From: [REDACTED]
Sent: 25 February 2015 15:02
To: Ross Leal
Subject: Re: Y/87/14/PL - Unit 4, Glebelands Farm, Yapton Road, Barnham

WOODHILL DESIGN & BUILD ~ 01243 850515
REF: GLEBELANDS FARM, YAPTON ROAD, BARNHAM
FLOOR PLAN UNIT 4 DATE: 26/10/2014
SCALE: 1:100 DWG: FL PLAN 01

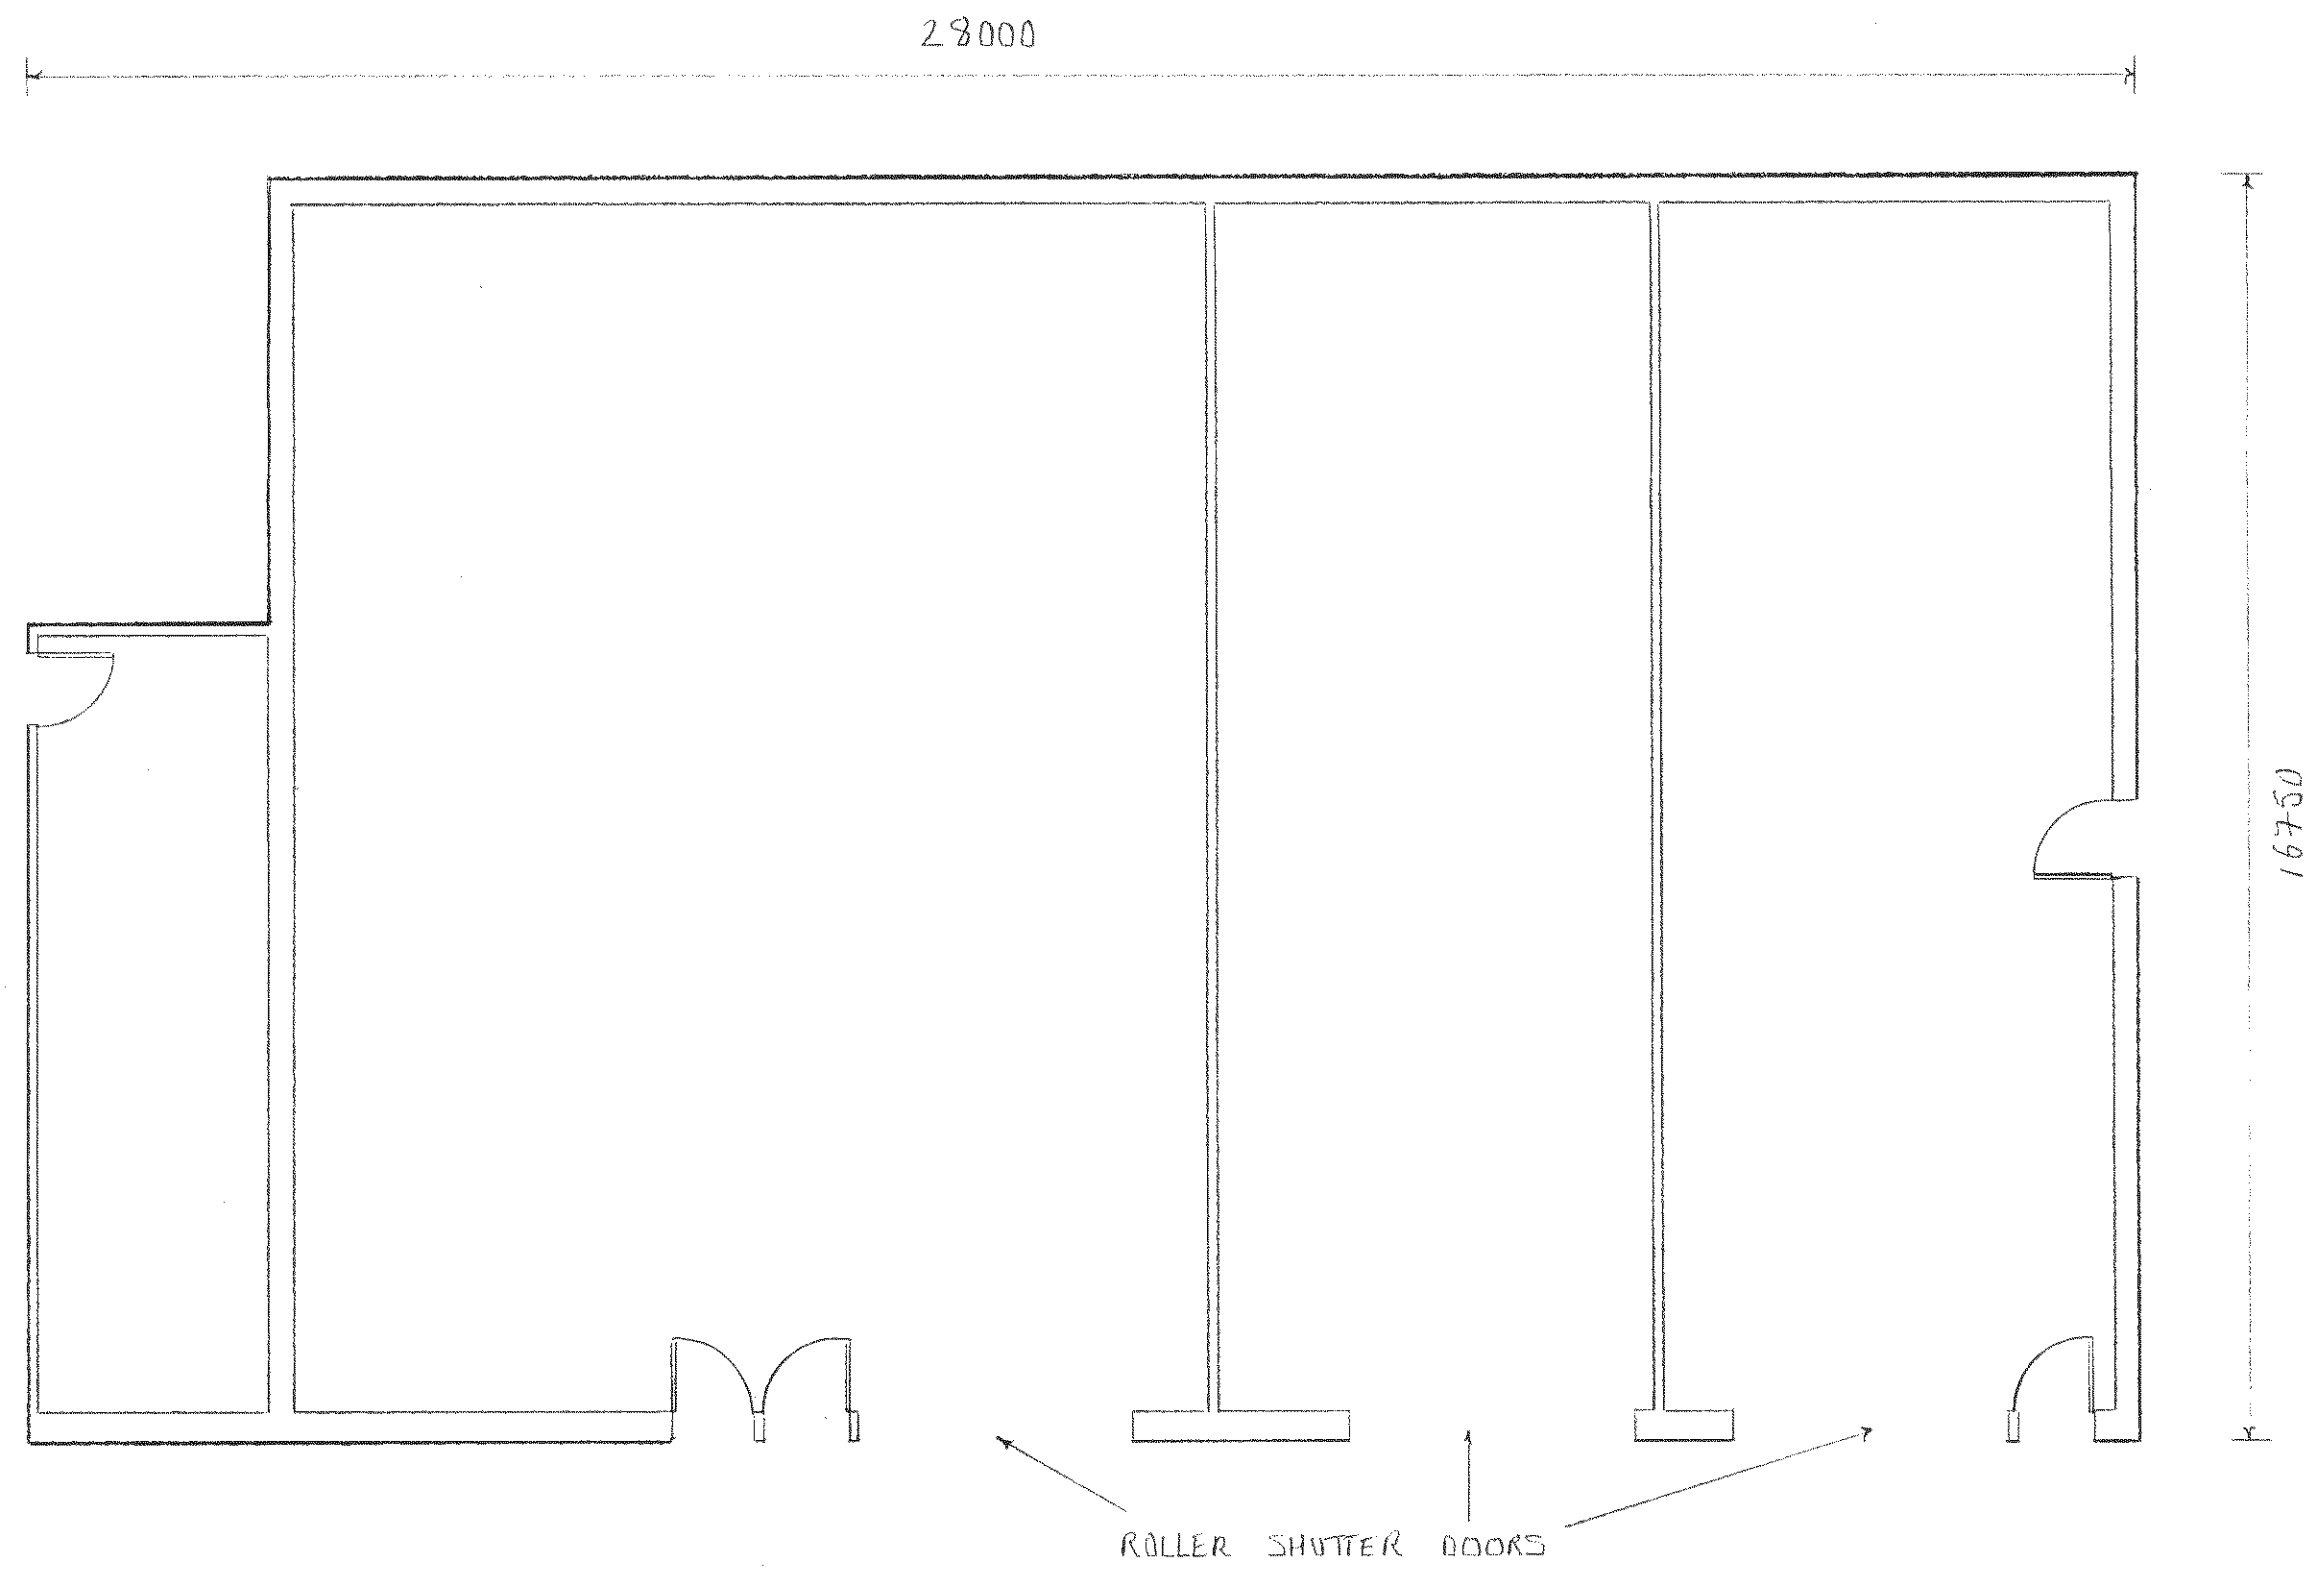
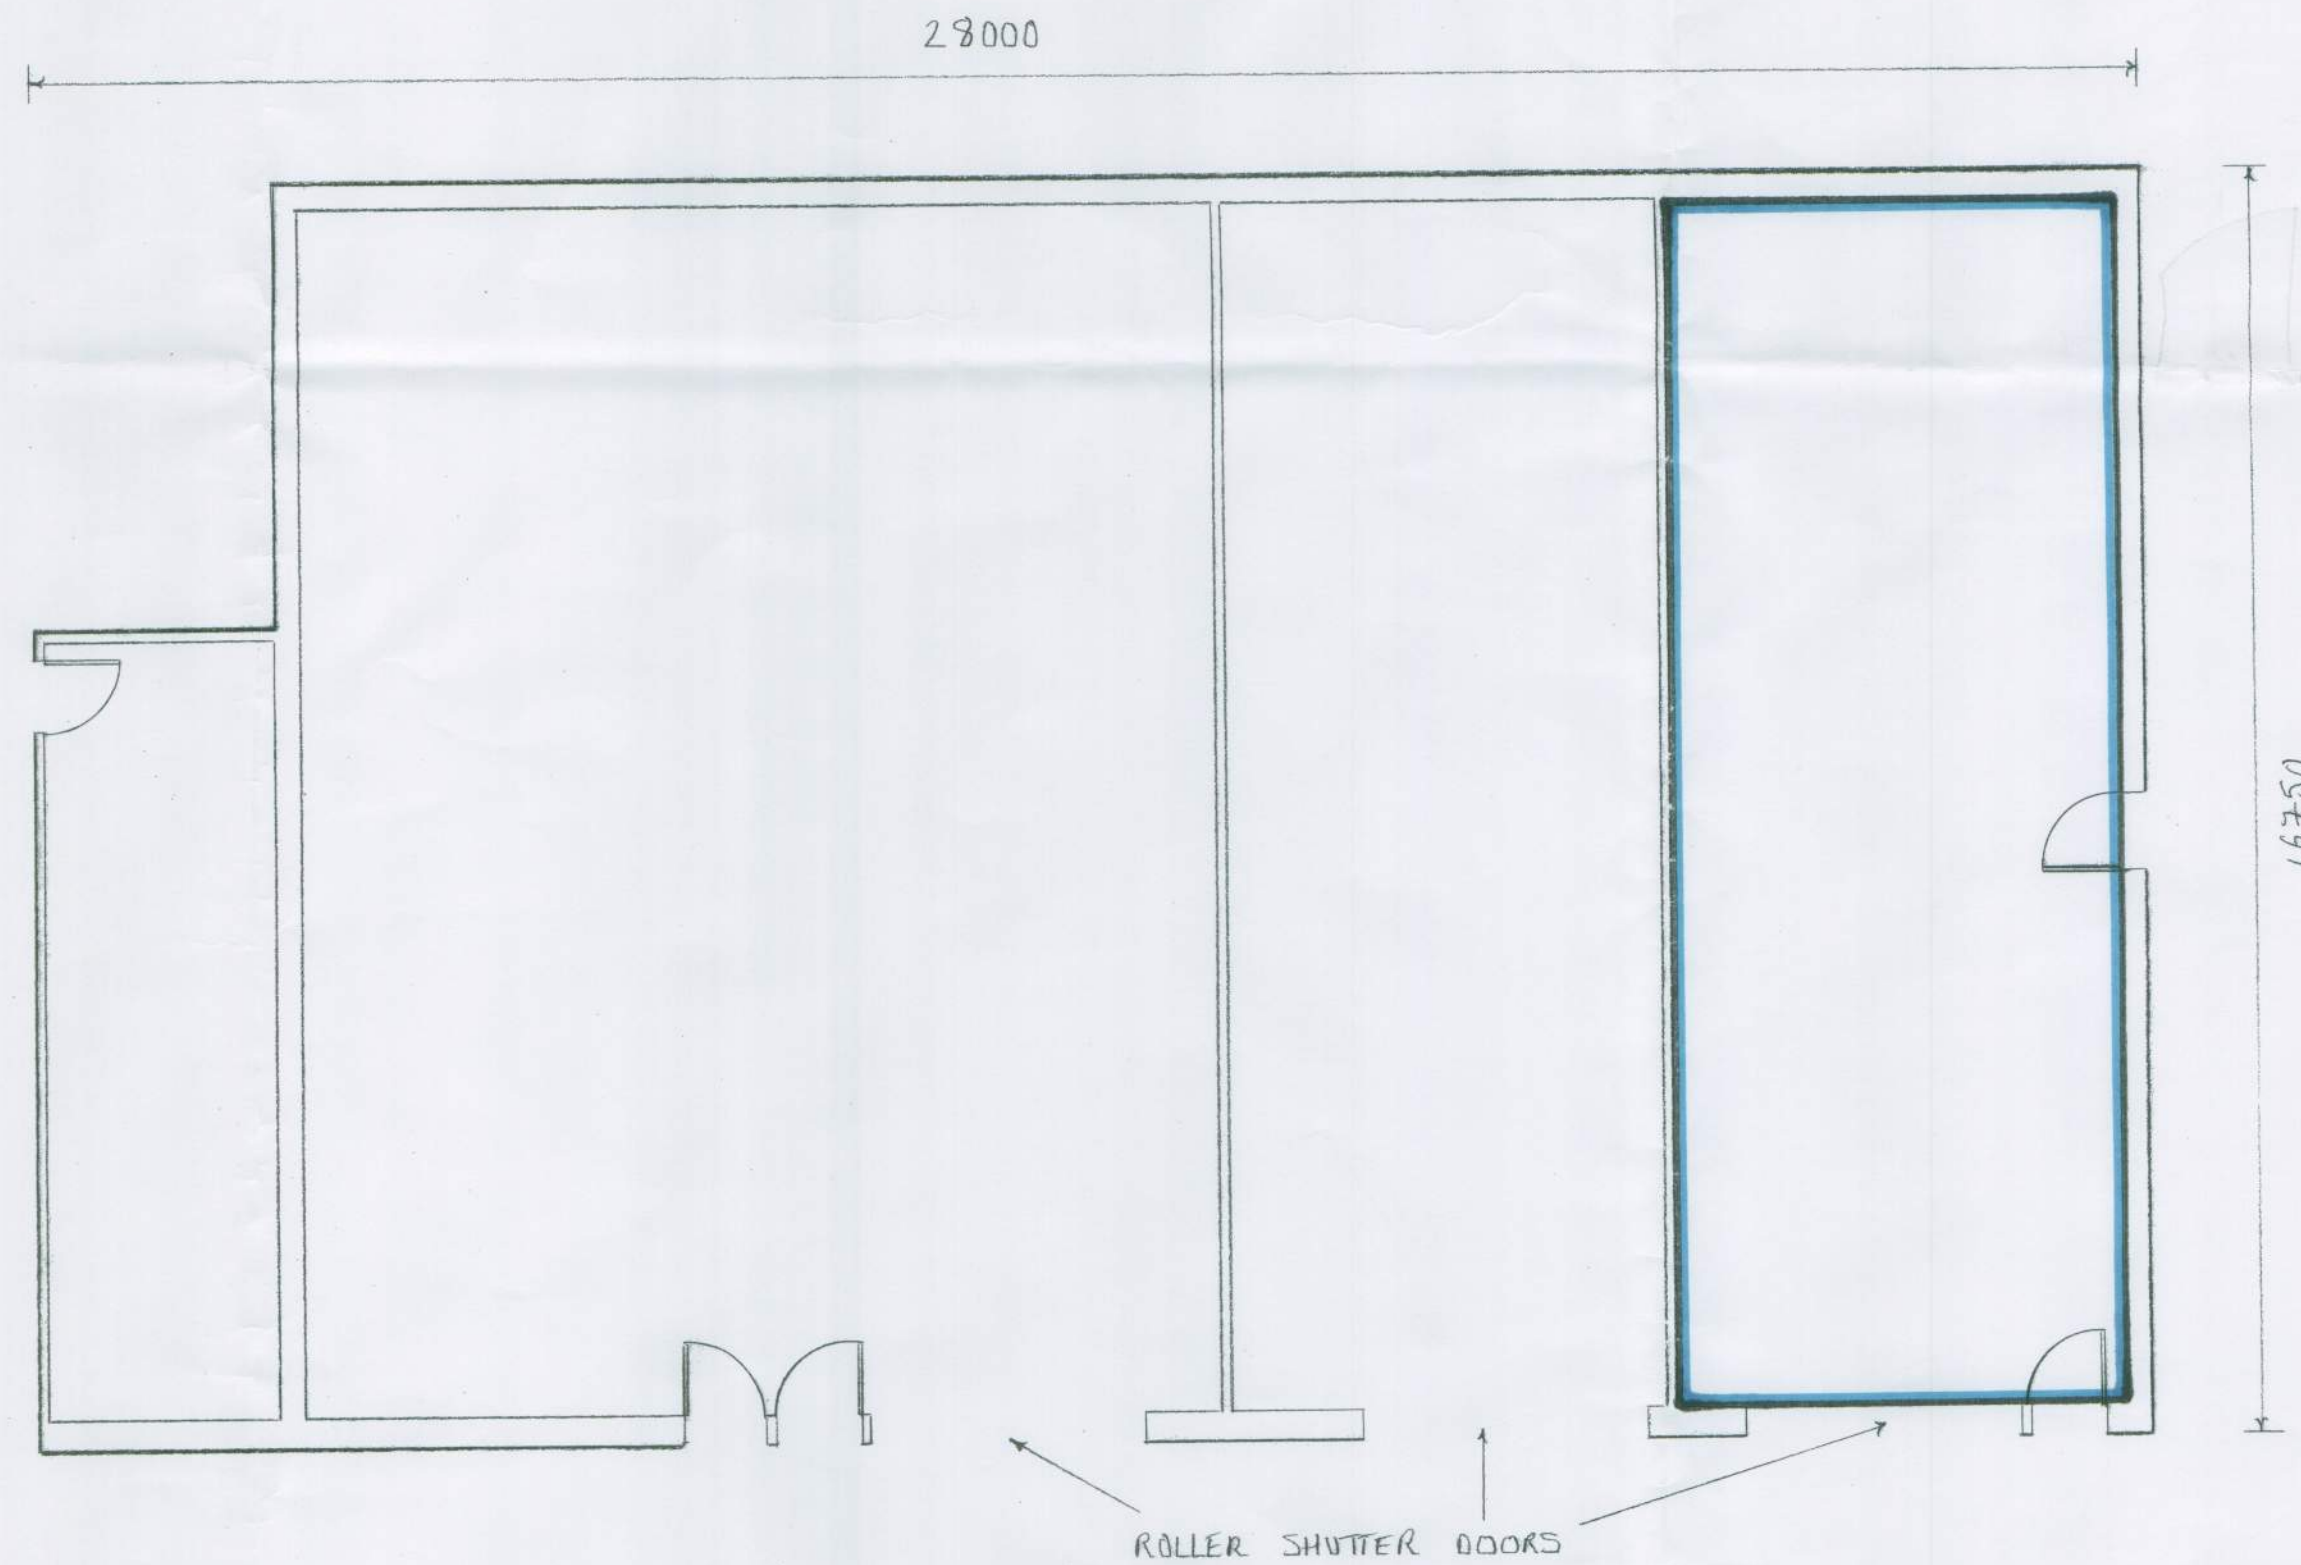
Also, as the application stands, we would be allowing the potential for an additional MOT station in another part of the unit in the future. Would this be a problem? If so, I'll get him to amend the floor plan to indicate where the MOT station is and then condition the MOT station to be as per the plans.

1. A condition restricting the type of MOT station (i.e. cars and vans only) and,
2. Getting a plan to show the specific area/bay (and conditioning this).
